Bryan G Norman, B.Sc. (Est Man.) F.R.I.C.S
Representation/Evidence to Planning Inspectorate
Ref A303, Sparkford to Ilchester Dualling

I will be providing evidence which support the major, in principle, objections of the Parish Councils of Queen Camel, West Camel and Sparkford together with Hazlegrove School, in relation to Highways England's design of Hazlegrove junction and the omission of a local parallel road from their application.

HAZLEGROVE JUNCTION

# AKT 4

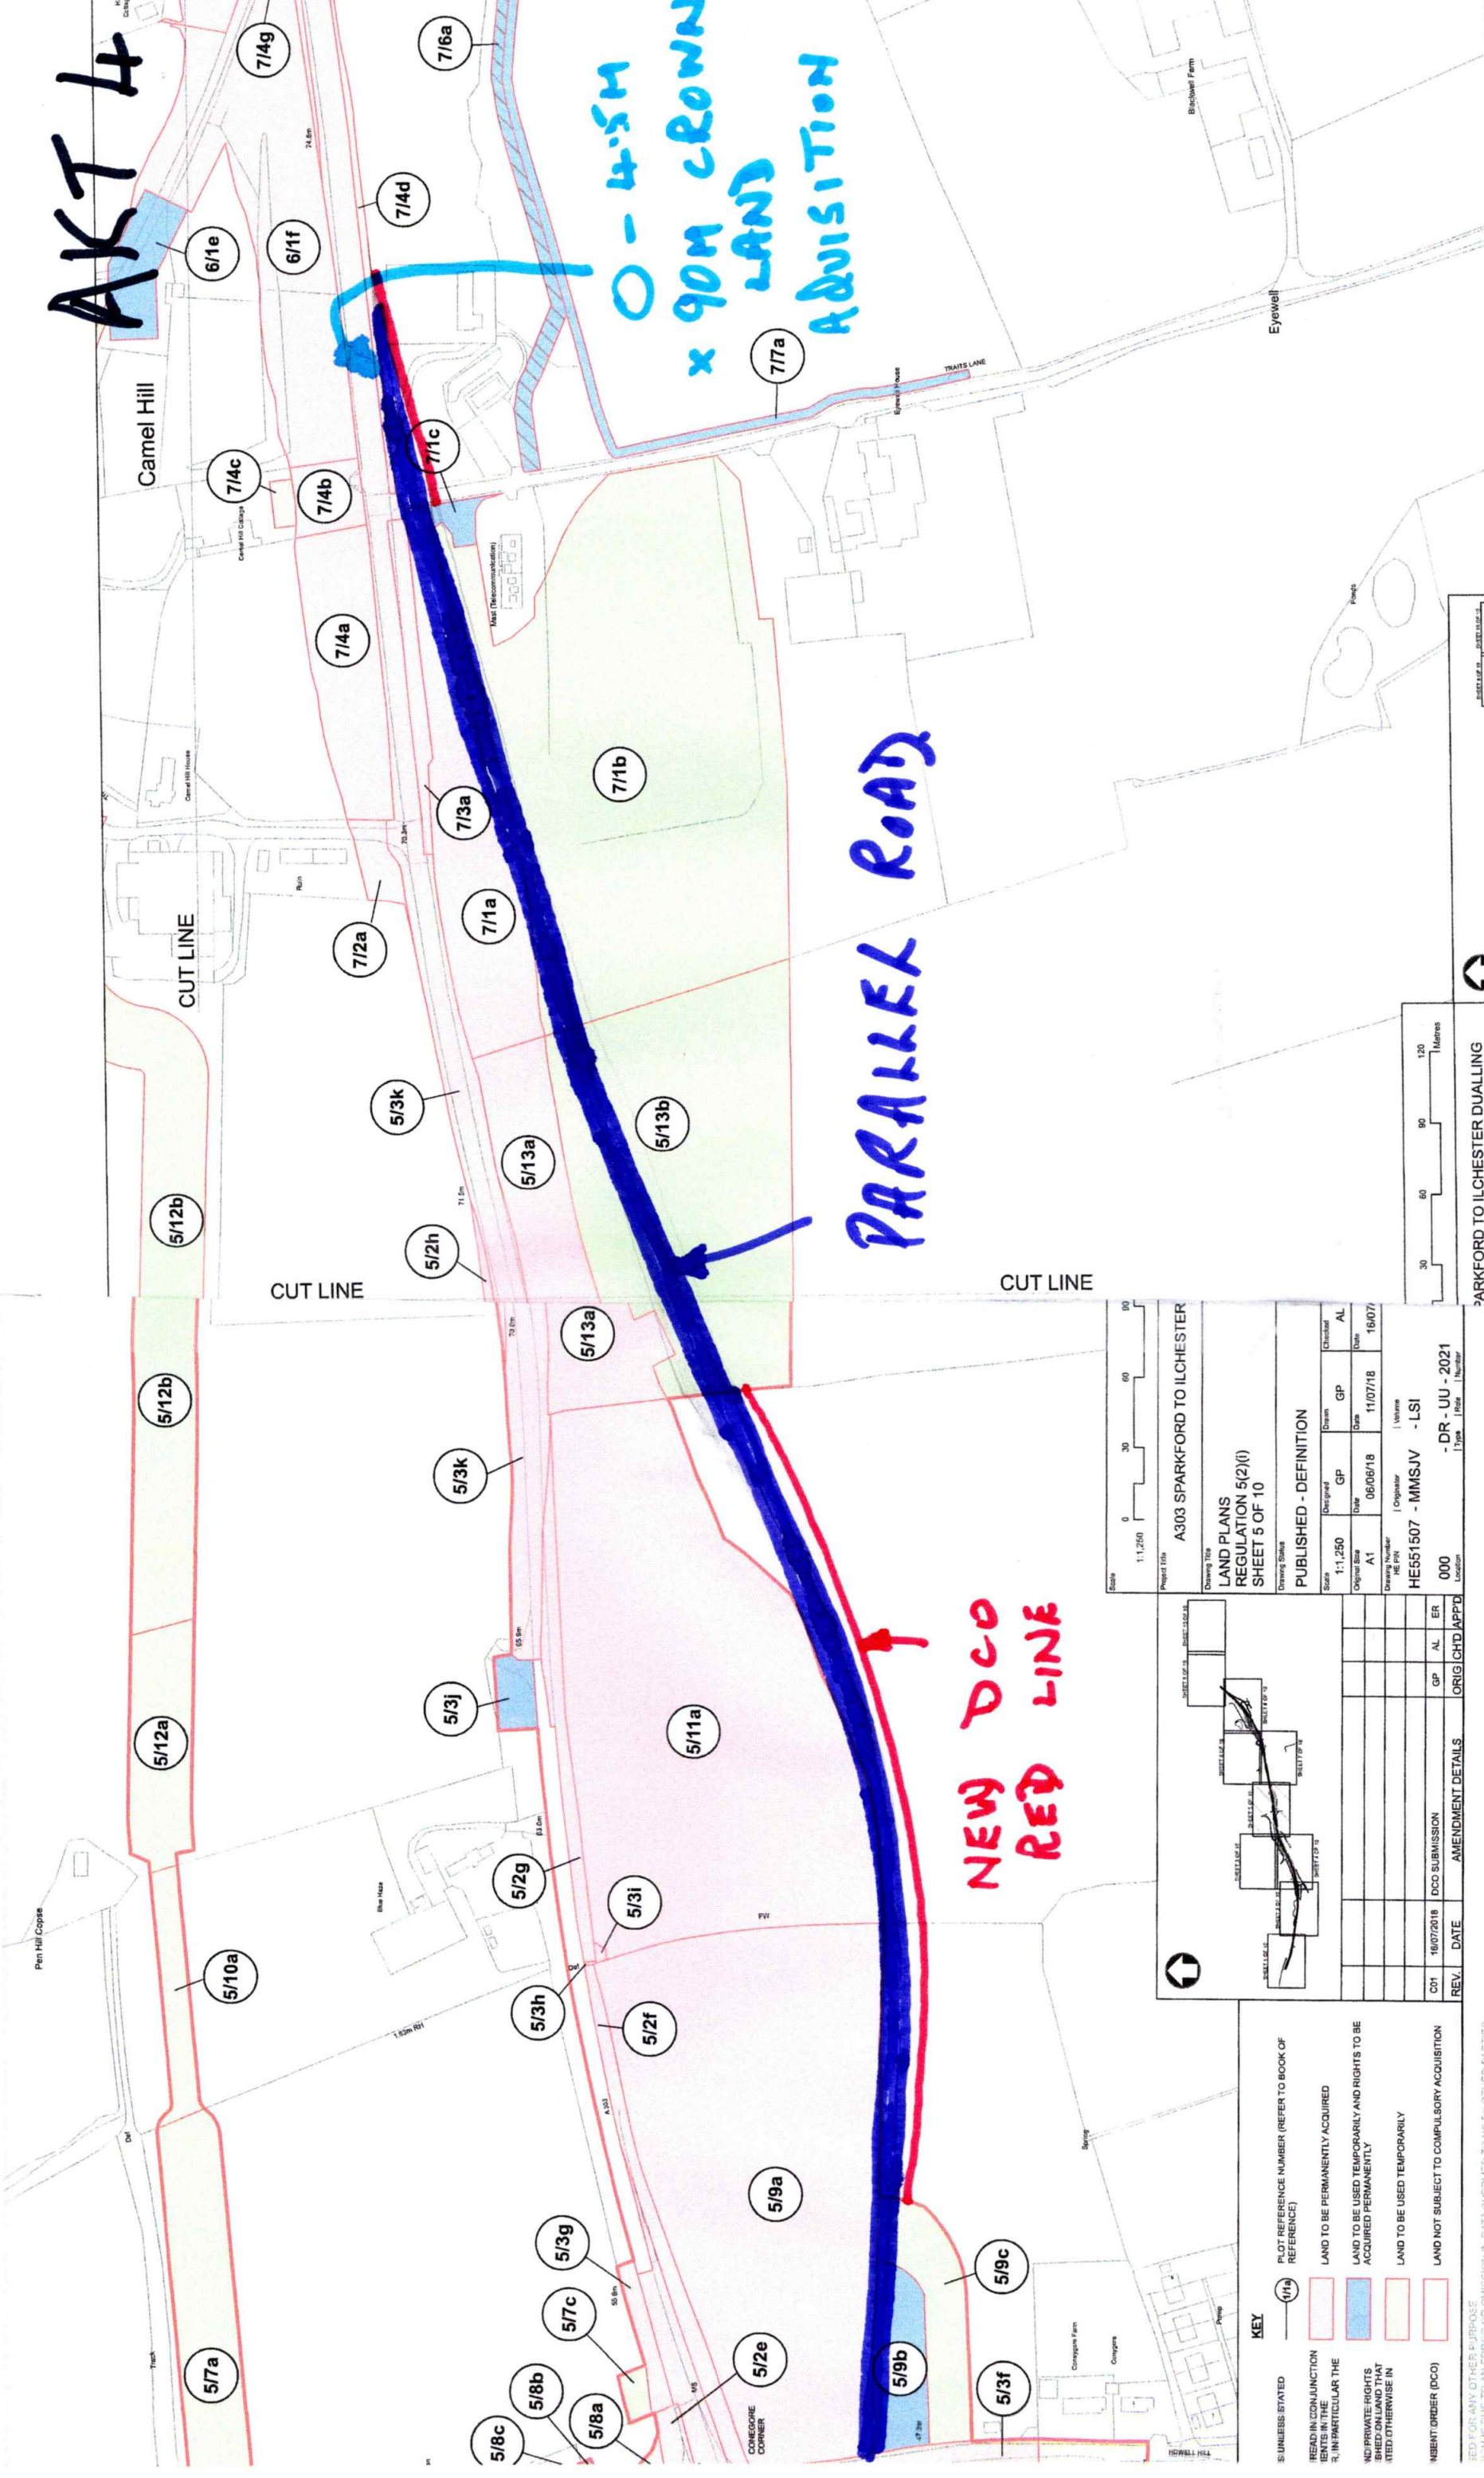
I have again referred this detail design problem to the **Highway Engineers Fairhurst** to be sure that three lanes can be accommodated at this pinch point and without affecting the local wildlife site as was envisaged at the time of the 1995 plans (see BGN 2). I submit drawing Nos 127643 / 1001/1002 prepared by Fairhurst, 'Proof of concept' in detail

The design criteria in the 'Manual of Road and Bridges, however, allows for an acceptable narrowing of the local road at this point to 6m (from 7.3). This could be avoided, however, if the small section of 4.5 m by 90.0m (coloured mauve on Fairhurst plan 127643 / 1002) of land on this corner was acquired from the MOD. It would make construction easier at this point and enable the full 7.3m width to be maintained.

I recommend an approach to be made to MOD to acquire rights over this land, it is not necessary, but preferable, should the P.I. and H.E. decide that the parallel road should be included. This small section falls within the area of a wildlife site of unimproved grasslands, although this classification might now be questioned. The area of 200 M² is under 1% of the total area of 2.175 H of the grassland site.

WORK NO.50 HAZLEGROVE
JUNCTION EASTBOUND OFF-SLIP

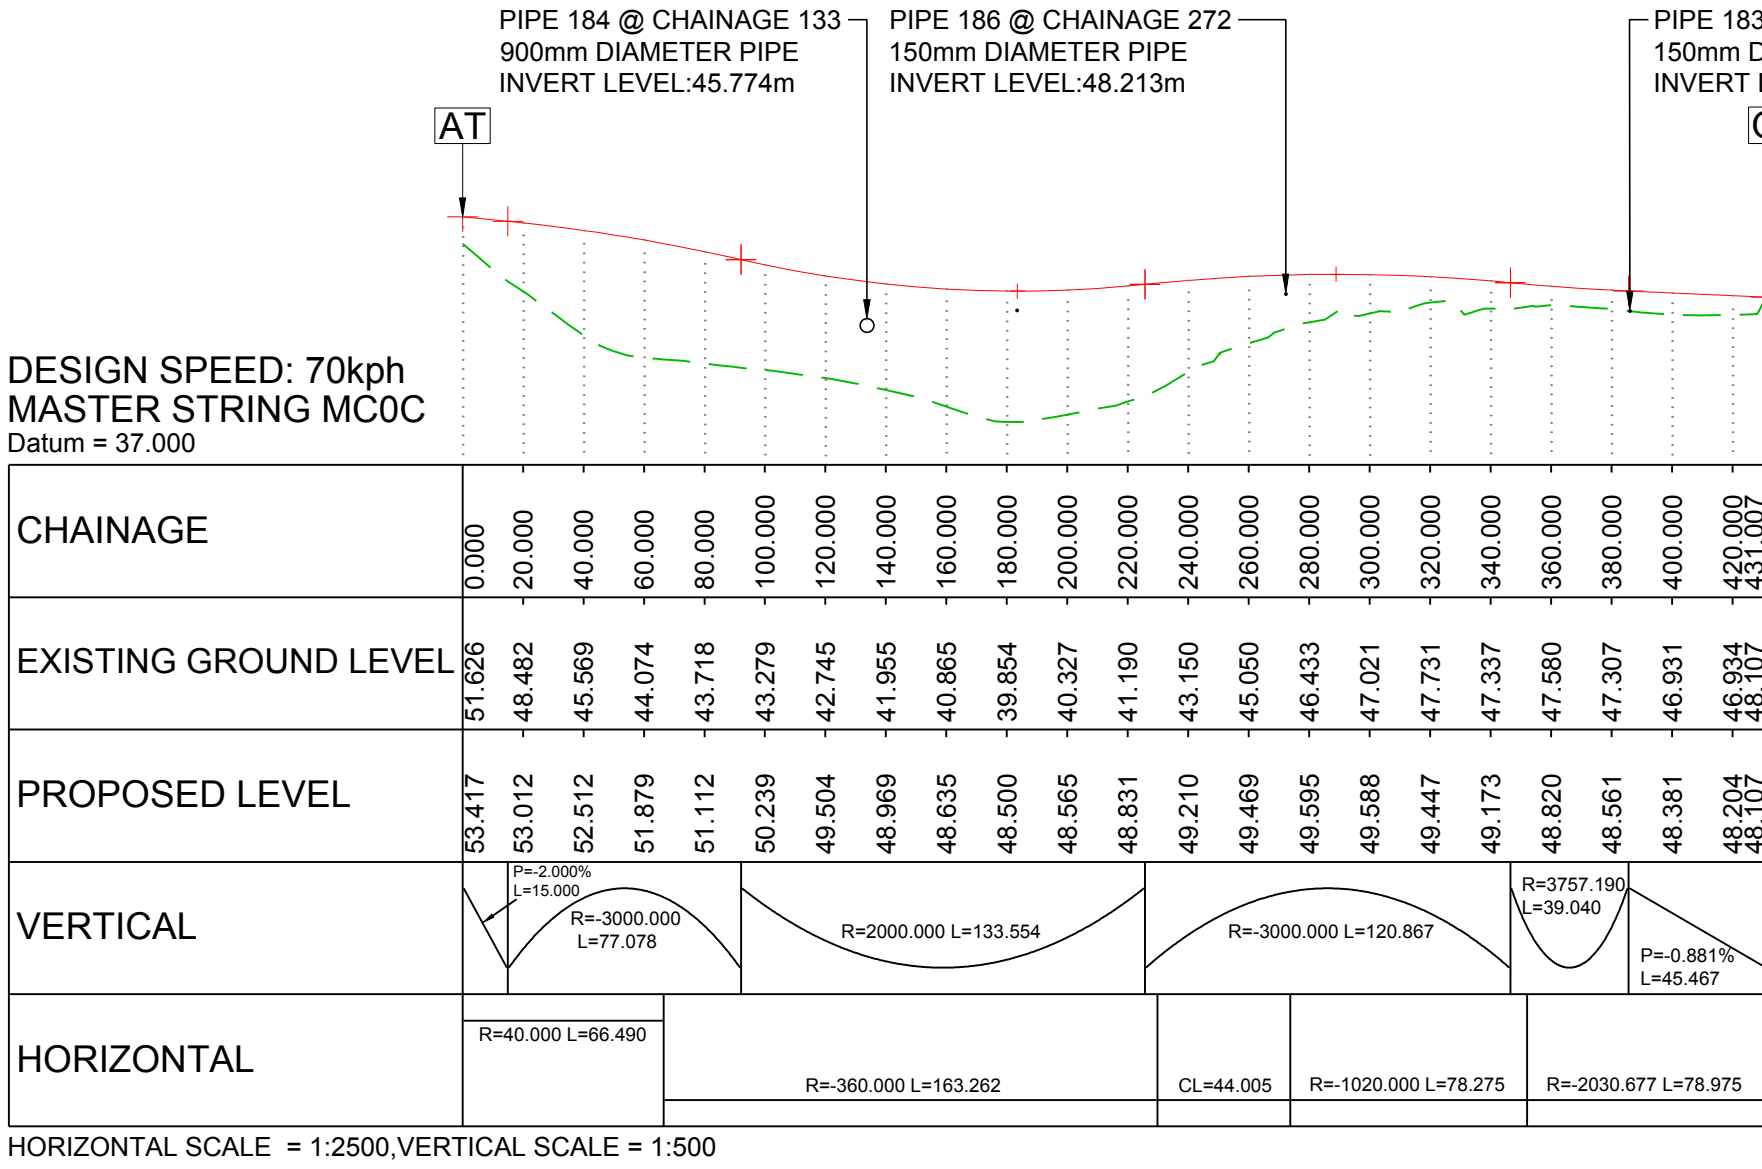
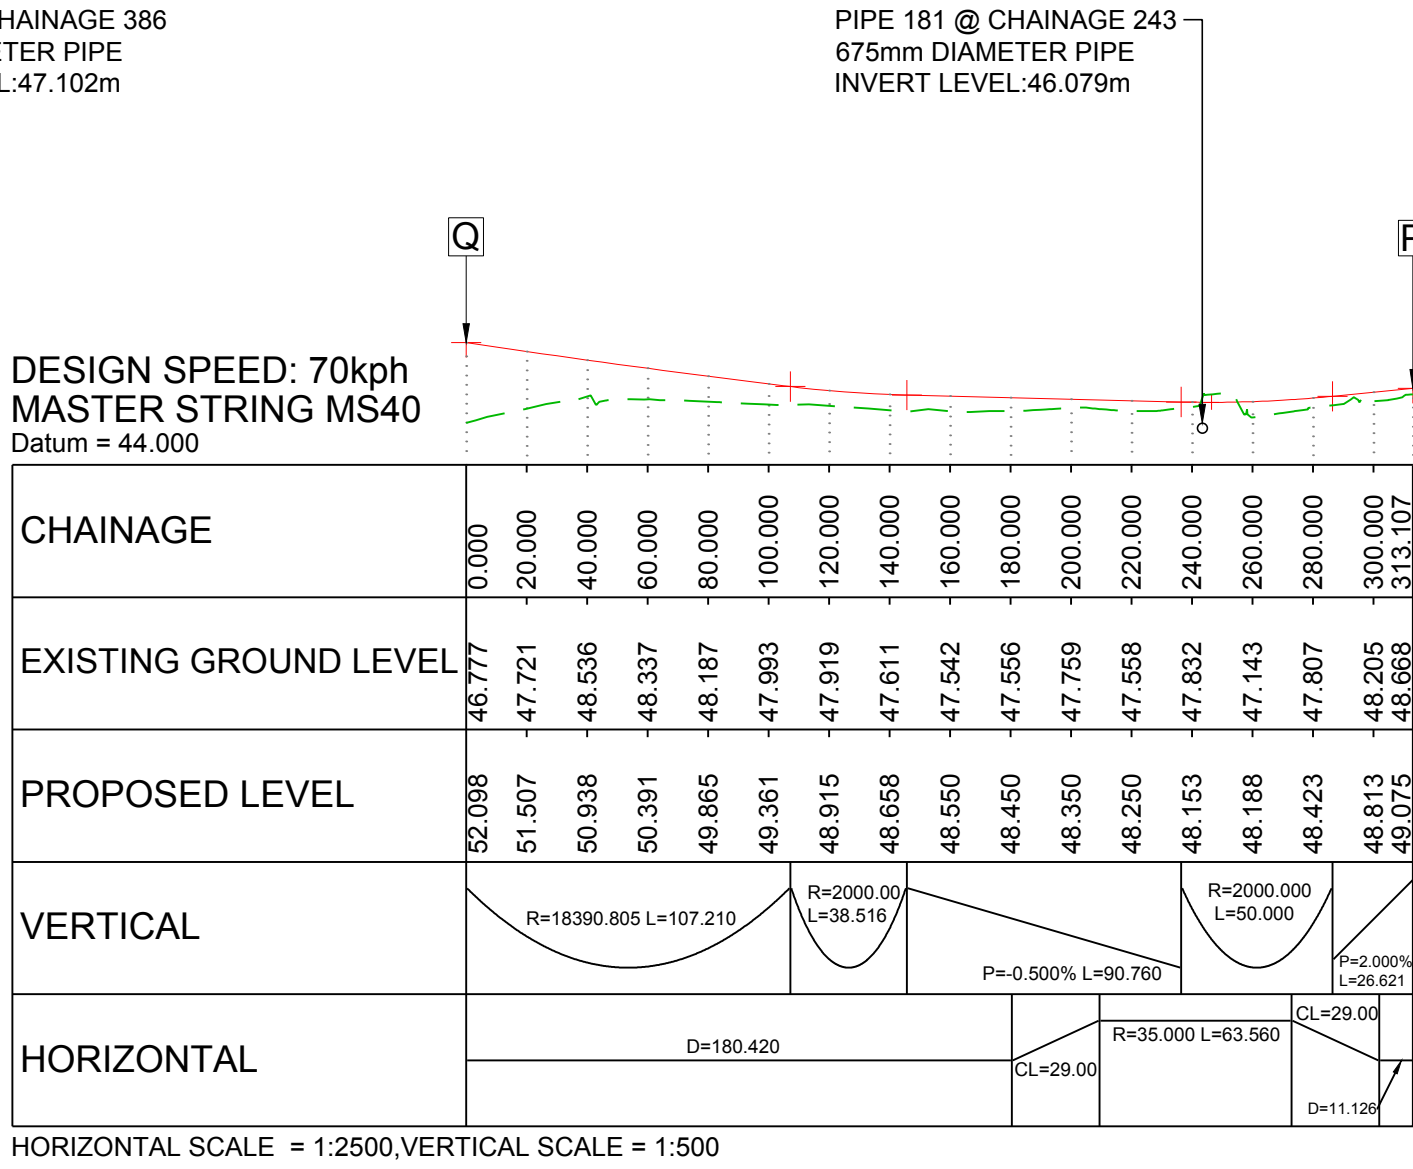
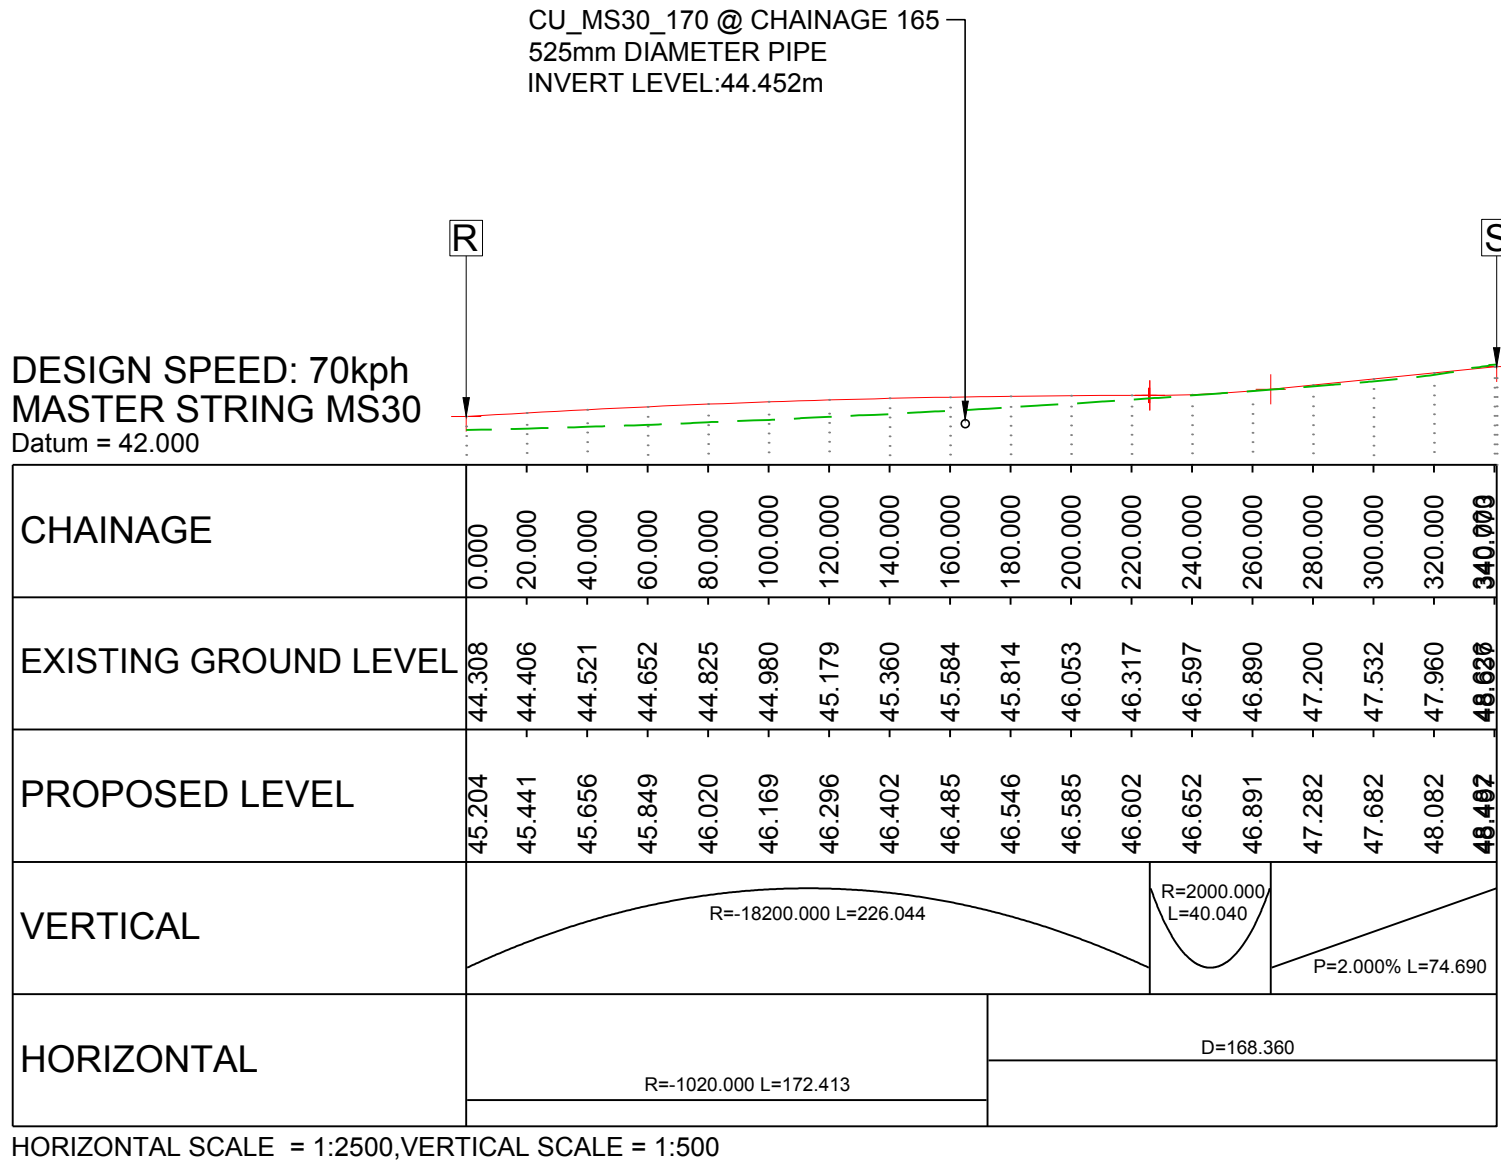
(a) Based on Queen Camel Traffic Survey 2017 (PF1 on A359 and subsequent observations that the design involves a 1.12Kilometre (K) detour from the existing (retained) roundabout for

Hazlegrove School users and a 0.82K detour for East on-slip users. This will amount to approximately **1,000,000K** of unnecessary travel per annum, in perpetuity.

Furthermore, conflicts at the right turn to the East on-slip will cause grid lock at peak hours. The full calculations supporting these conclusions are set out in P. Farrar's attached document (marked FP1).

I draw your attention to the Road Safety Audit July '18, in particular para 4.9.9. which states that *'provision of right turn facilities have been investigated but are not considered necessary due to the relatively low flows associated with traffic travelling West on Camel Hill link. The majority of traffic will be turning right onto the East on-slip and therefore, slowing.'*

This may be true at non-peak hours, where less than 100 vehicles per hour will meet some 220 making this turn. Due to the complication of the school, these figures drastically change at peak hours, where approximately 600 vehicles meet 280 travelling in the opposite direction, which will lead to vehicles backing up to Sparkford roundabout within 10 minutes.
